### STAFF REPORT

#### White Barn Retreats Conditional Use Permit (CU-24-00004)

TO: Kittitas County Hearing Examiner  
FROM: Jamey Ayling, Planning Manager  
RE: White Barn Retreats Conditional Use Permit (CU-24-00004)  
DATE: July 24, 2024 (Hearing Date)

- Site Plan -

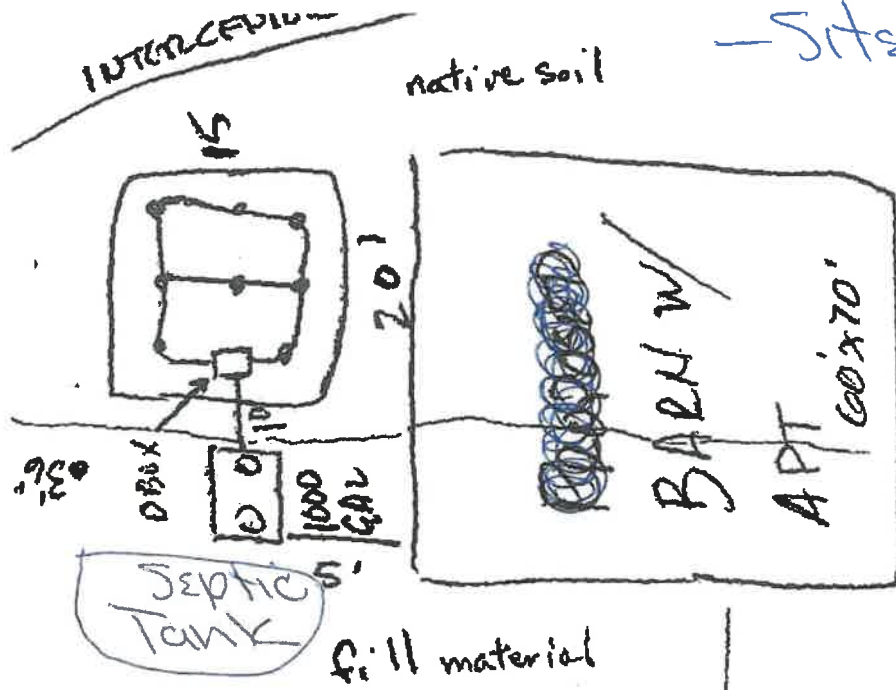
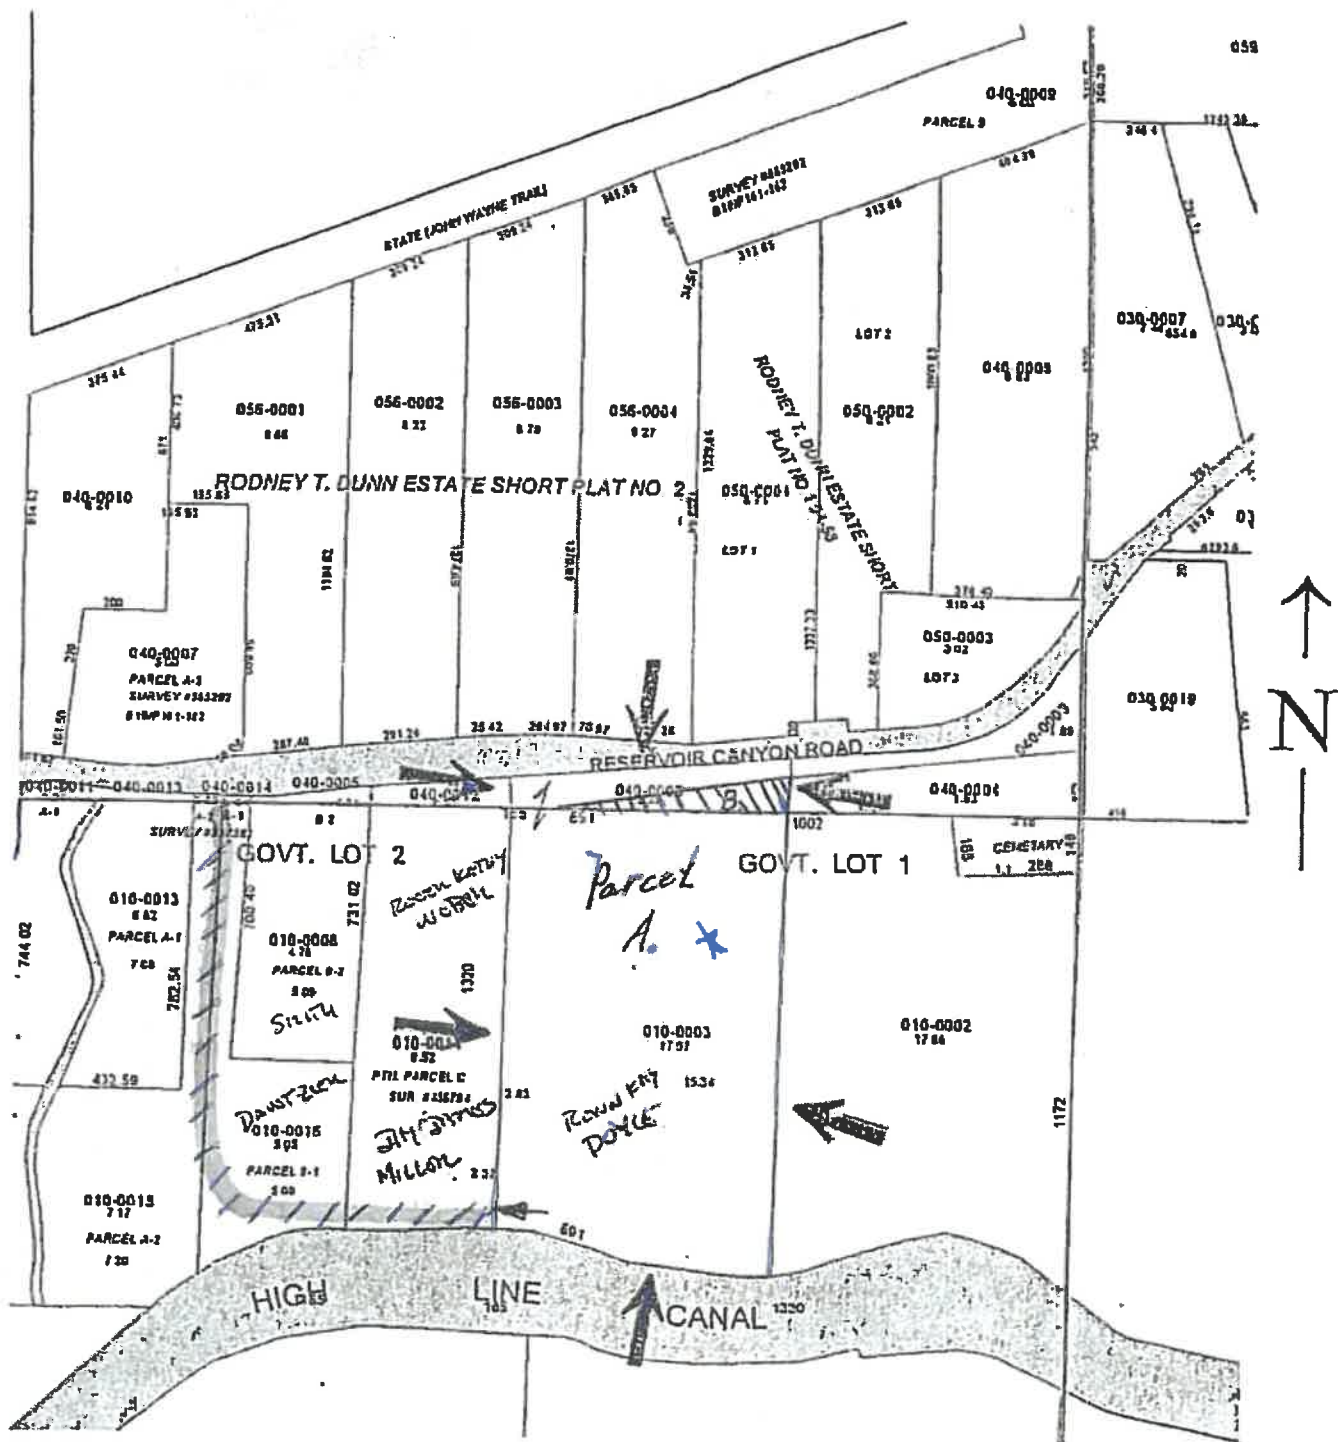
12. The grass/pasture area shall be mowed for parking prior to any events that will utilize this area for parking and have fire extinguishers readily available in this area.

14. Accessible parking and route to Accessible space(s) provided with hard surface such as asphalt or concrete shall be required. The parking symbol and signage of Accessibility is required. Accessible parking spaces shall be located on the shortest accessible route of travel from adjacent parking to an accessible building/ pedestrian entrance per WAC 51-50-1106. Wherever practical, the accessible route shall not cross lanes of vehicular traffic. Where crossing traffic lanes as necessary, the route shall be designated and marked as a crosswalk.

Verify there is no more than 1:20 slope for the Accessible path from Accessible Parking to the building(s) and all facilities entrances and amenities. Please show path and state the maximum allowed slope on the drawings.

Please show this accessibility on an updated site plan and building permits for approval. Accessibility requirements must be approved by Kittitas County Community Development Services prior to any events taking place.
